Subject: FW: Application ref: P/116/20/CLP - 16 Lagoon Road, Pagham - Proposed timber framed detached single garage

Subject: Application ref: P/116/20/CLP - 16 Lagoon Road, Pagham - Proposed timber framed detached single garage

Mr. P. Barnes
16 Lagoon Road
Pagham PO21 4TJ
PROPOSED ELEVATIONS
Date; October 2020 Scale 1:100

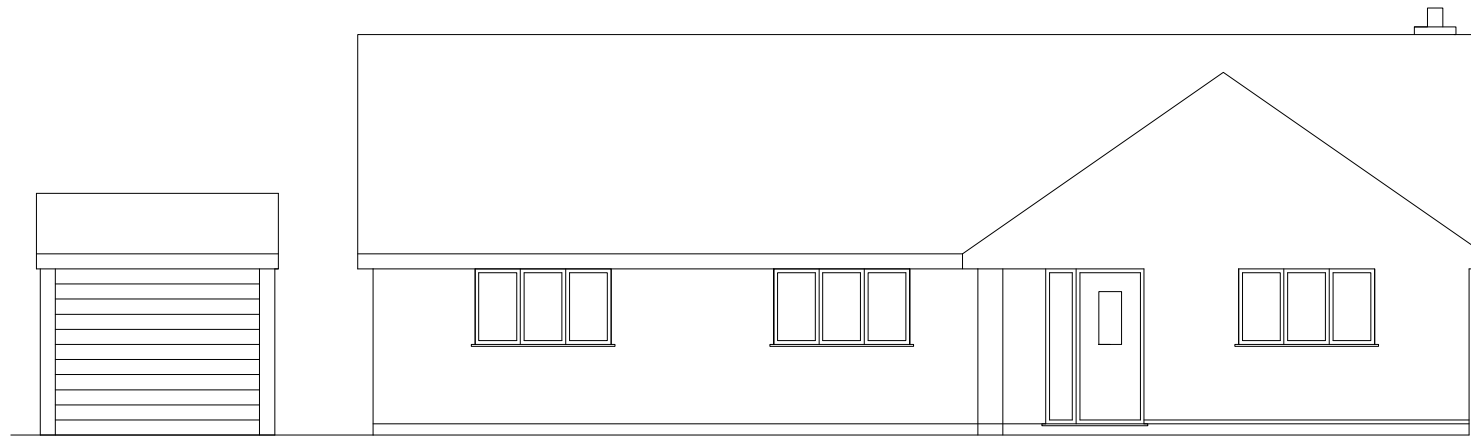
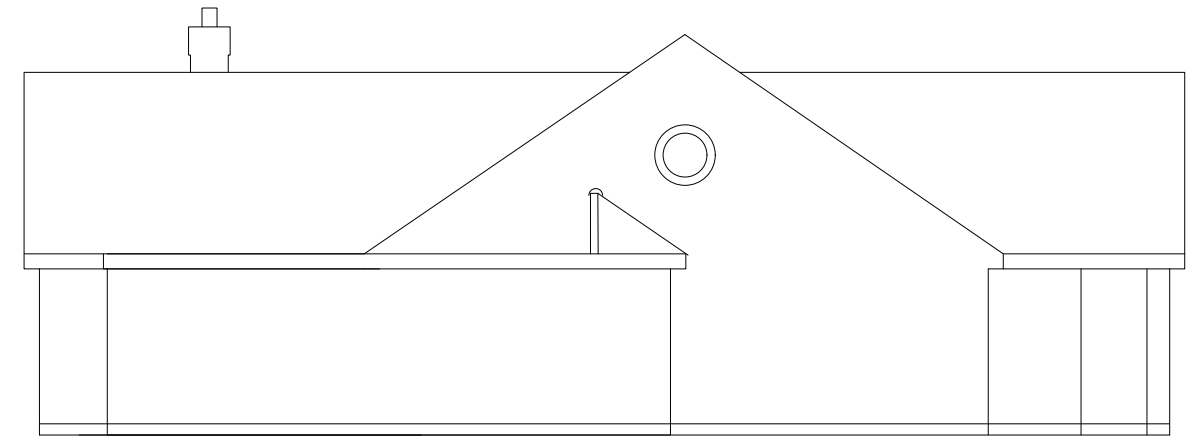
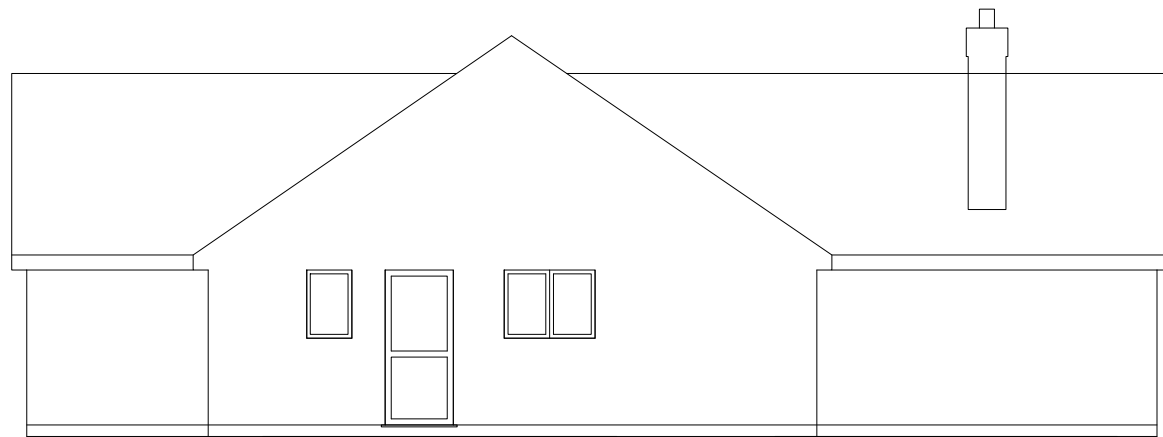
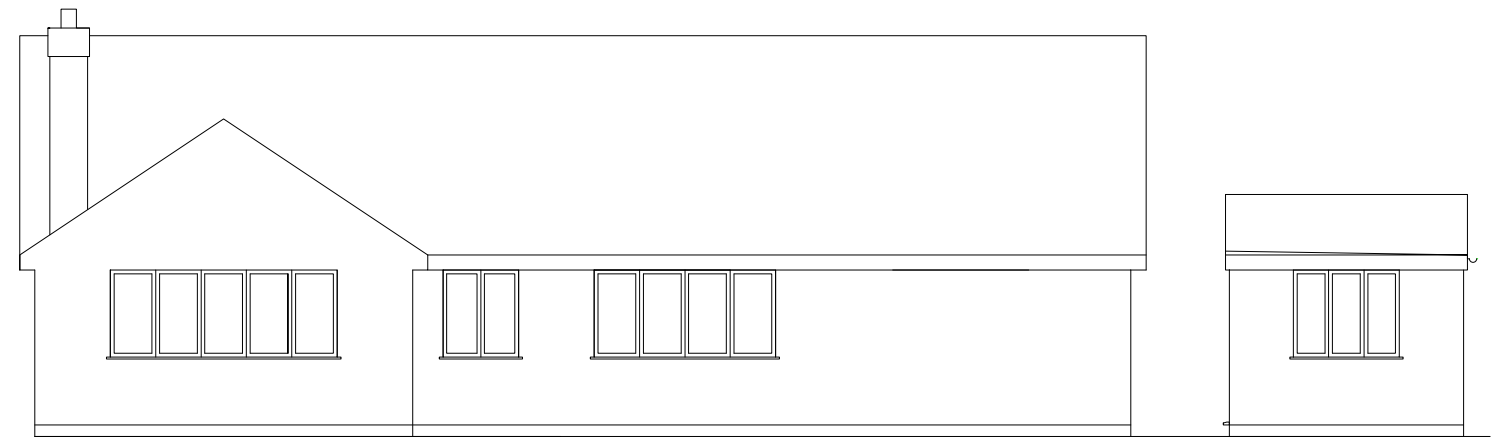
The proposed new garage is to be situated on a restricted plot and does not appear to allow adequate fire protection/separation between the Application boundary and the proximity of the existing bungalow, particularly having regard to the timber frame construction of the garage and the position of existing and proposed windows.

Mr. P. Barnes
16 Lagoon Road
Pagham PO21 4TJ
PROPOSED FLOORPLANS
Date; October 2020 Scale 1:100

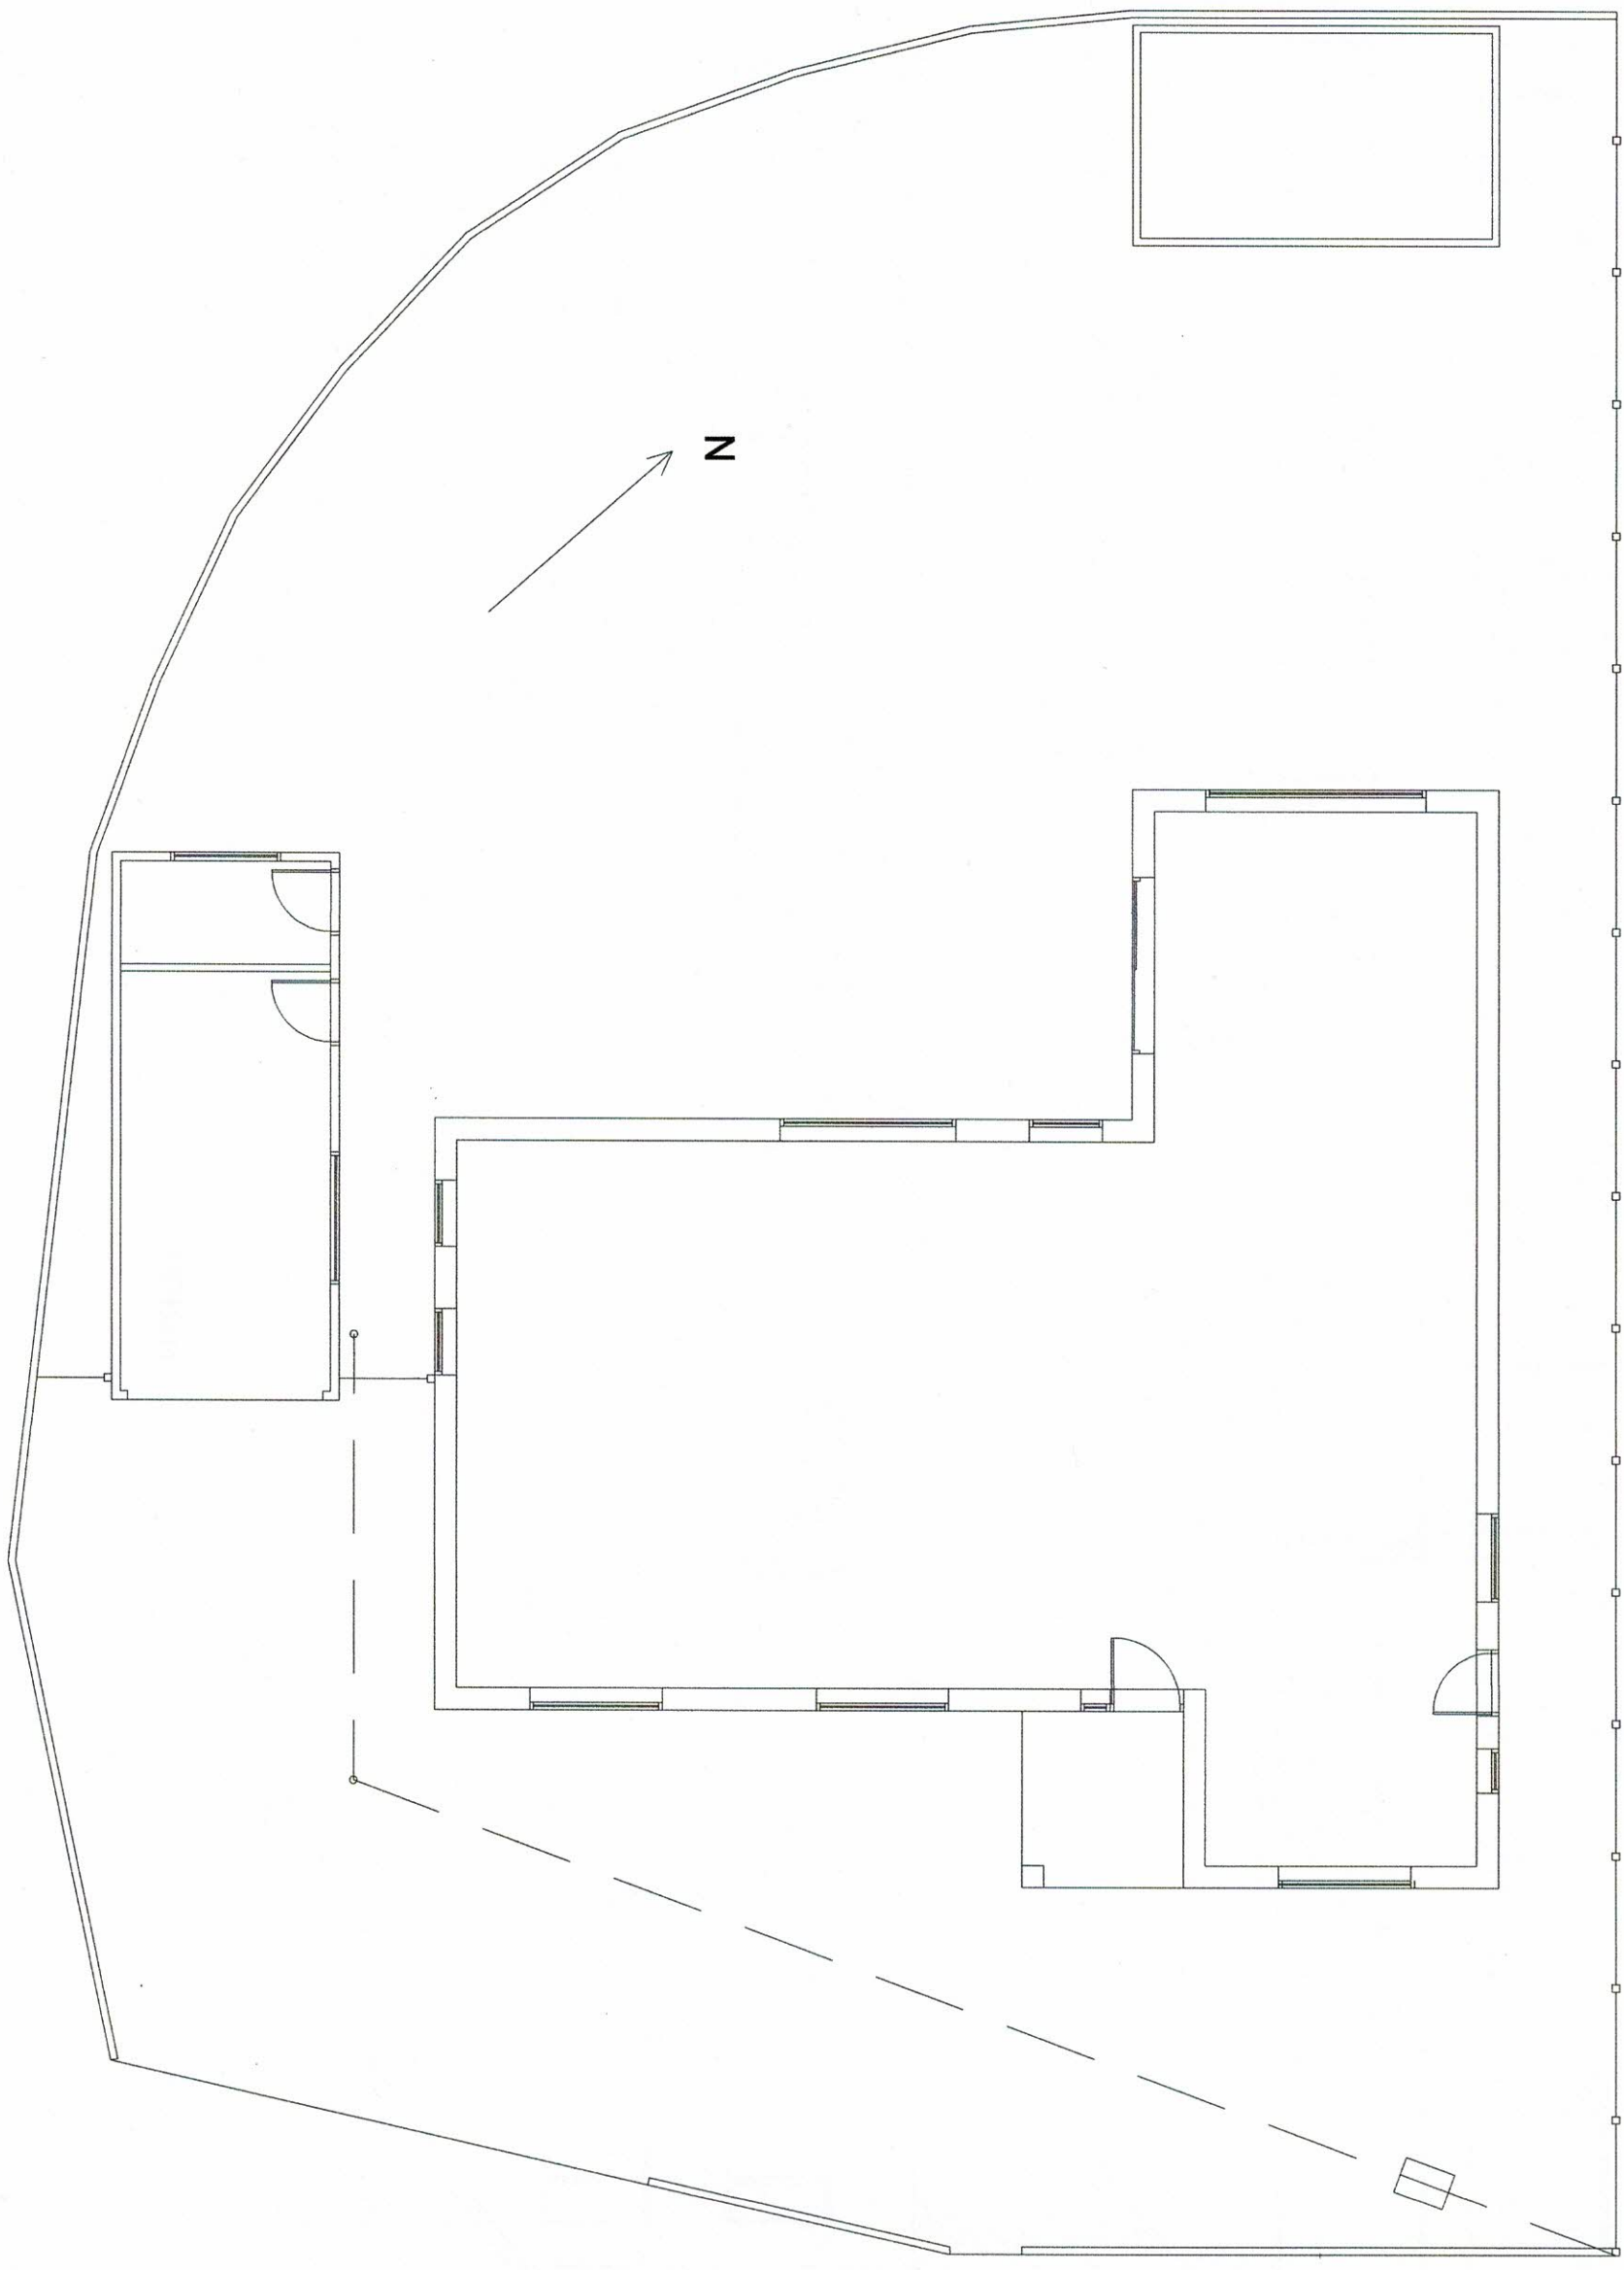
It therefore appears that the construction proposed does not comply with Part B of Building Regulations and should therefore not be approved as currently proposed.
